Your Ref: 2026/91969
Our Ref: B/02188

26th August 2026

land off, Fenay Lane, Almondbury, Huddersfield, HD5 8UJ - (KIRK) - Erection of 6 dwellings, with associated access, landscaping, infrastructure and works

Drawing Title
Drainage Plan

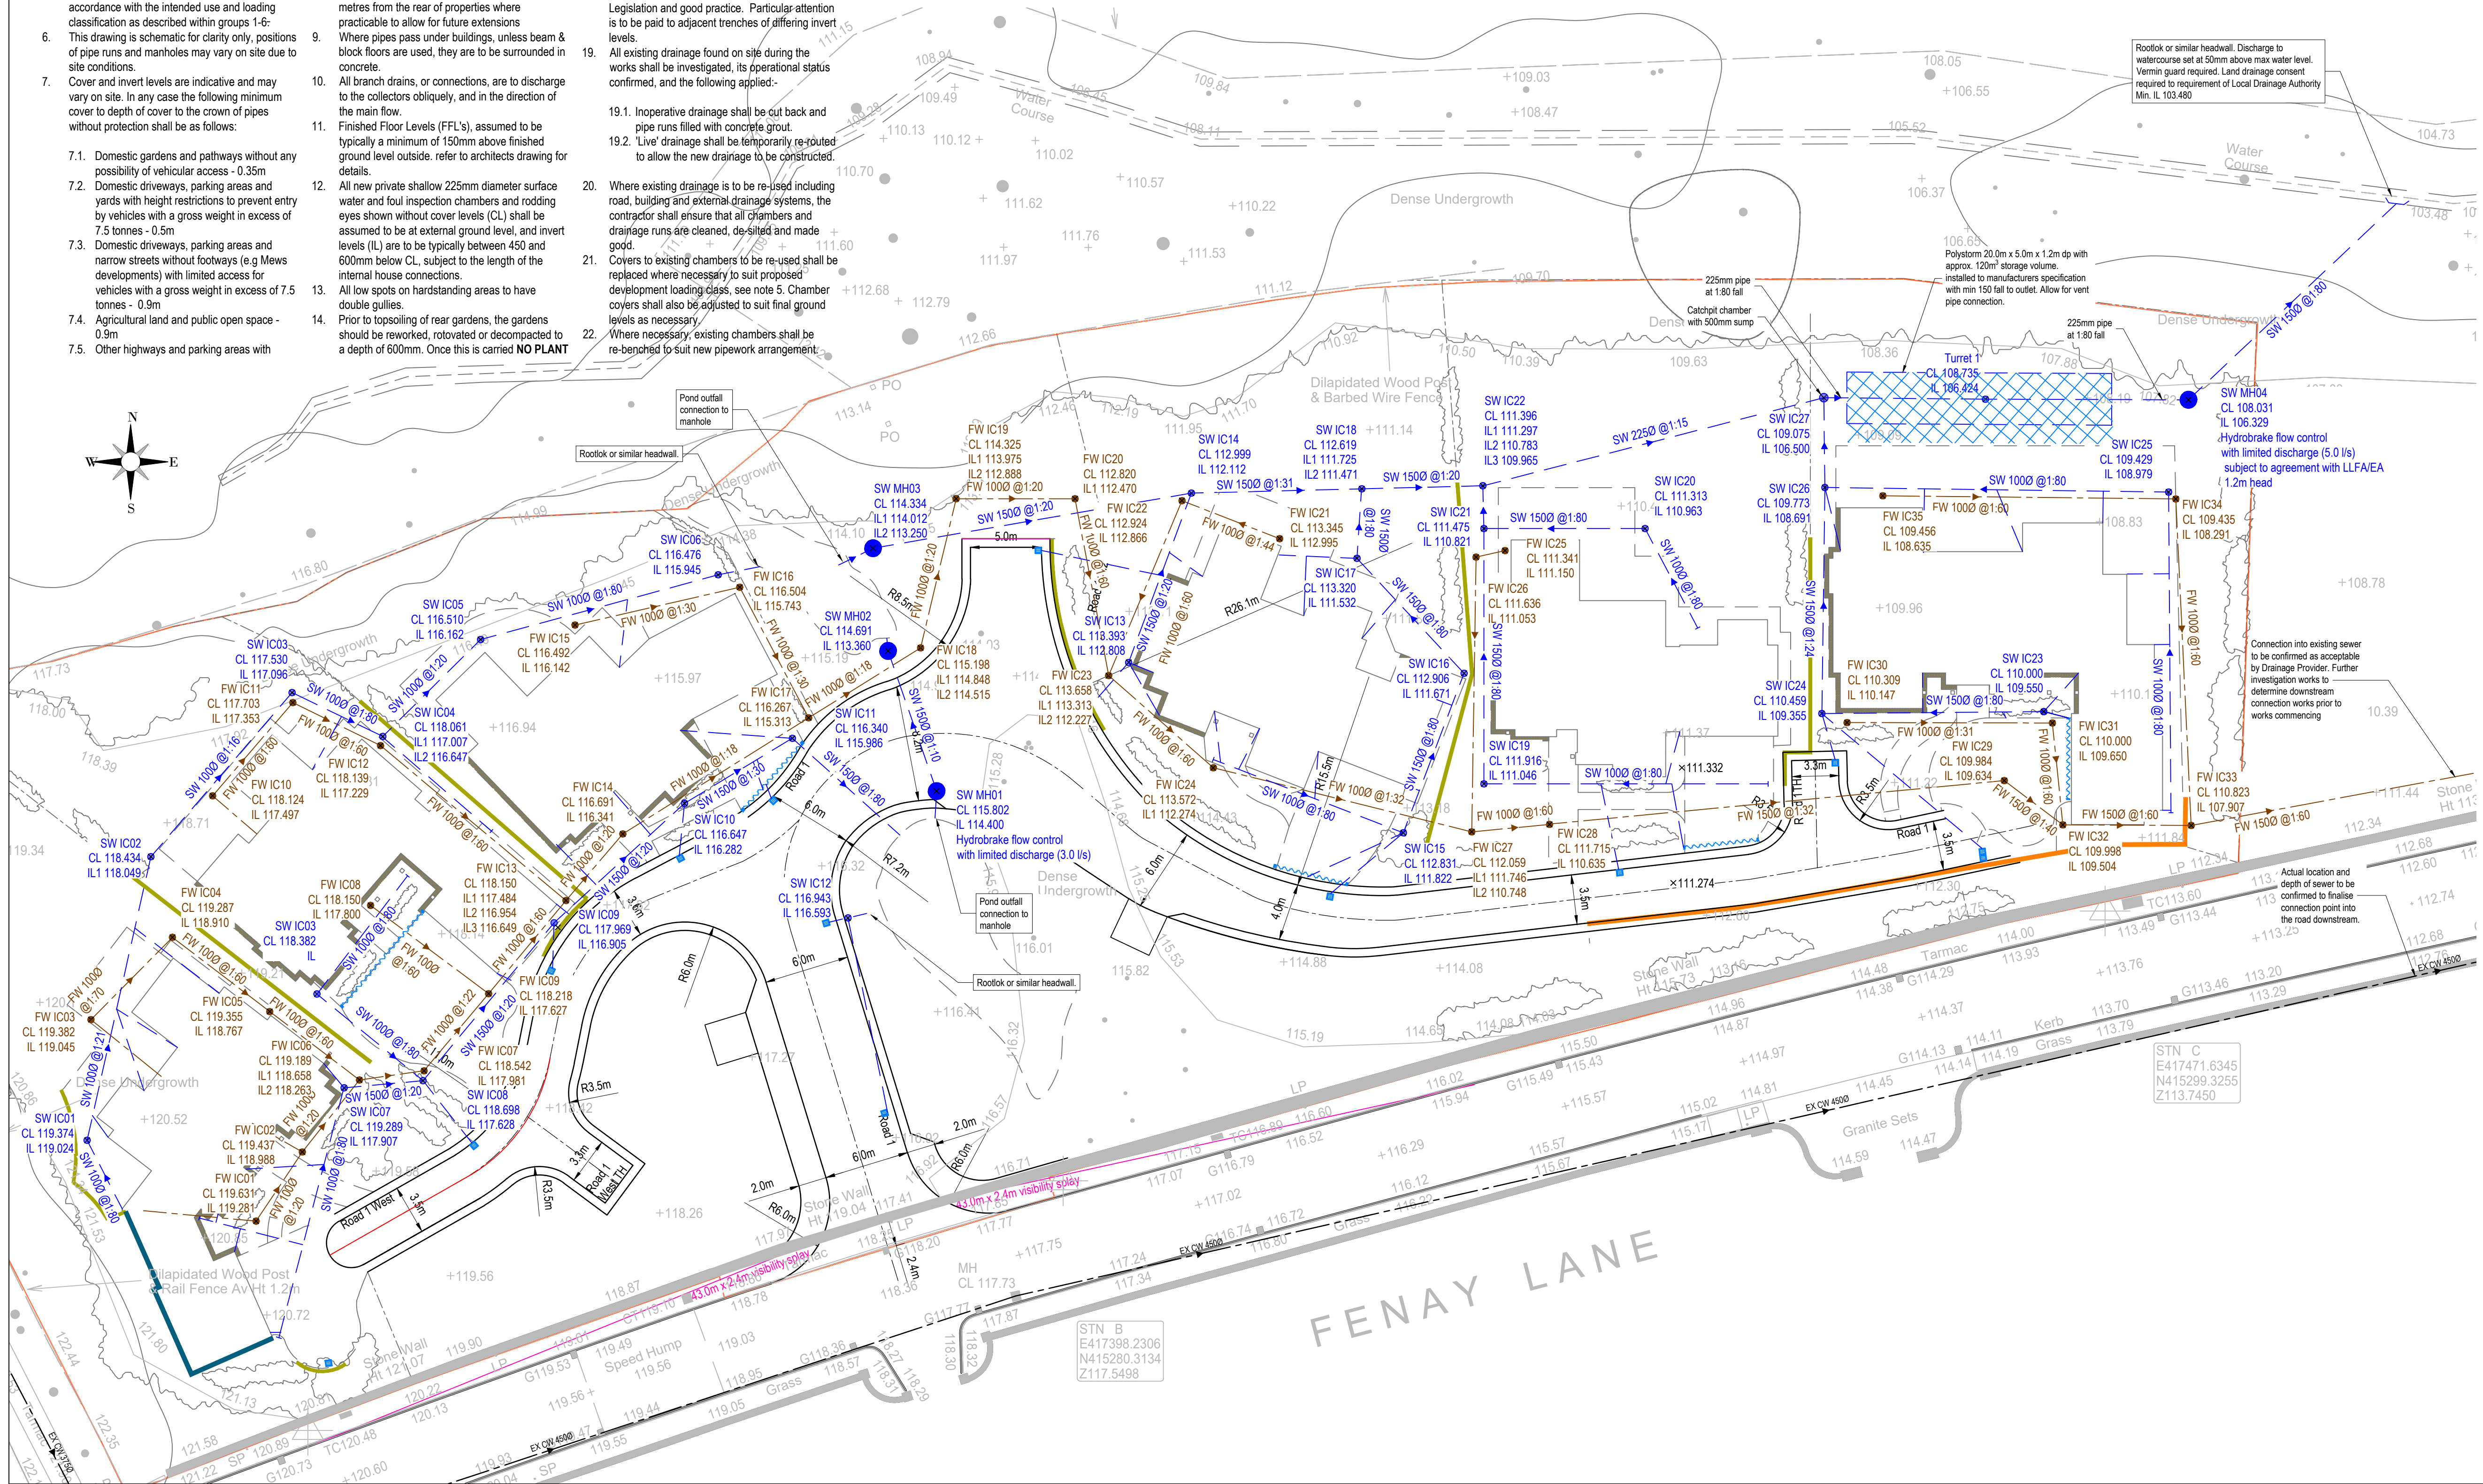
It is noted from the submitted Drainage Strategy (26-255) dated 06/07/2026 prepared by Holdgate Consulting proposes foul water to be discharged to 450mm diameter sewer along Fenay Lane. This is acceptable to Yorkshire Water.

The aforementioned Drainage Strategy proposes that surface water shall be discharged to the adjacent watercourse via attenuation at a maximum restricted flow rate of 5.0 litres per second. This is acceptable to Yorkshire Water.

The development shall be carried out in accordance with the details shown on the submitted plan, "Drainage Strategy (26-255) dated 06/07/2026 prepared by Holdgate Consulting", unless otherwise agreed in writing with the Local Planning Authority.
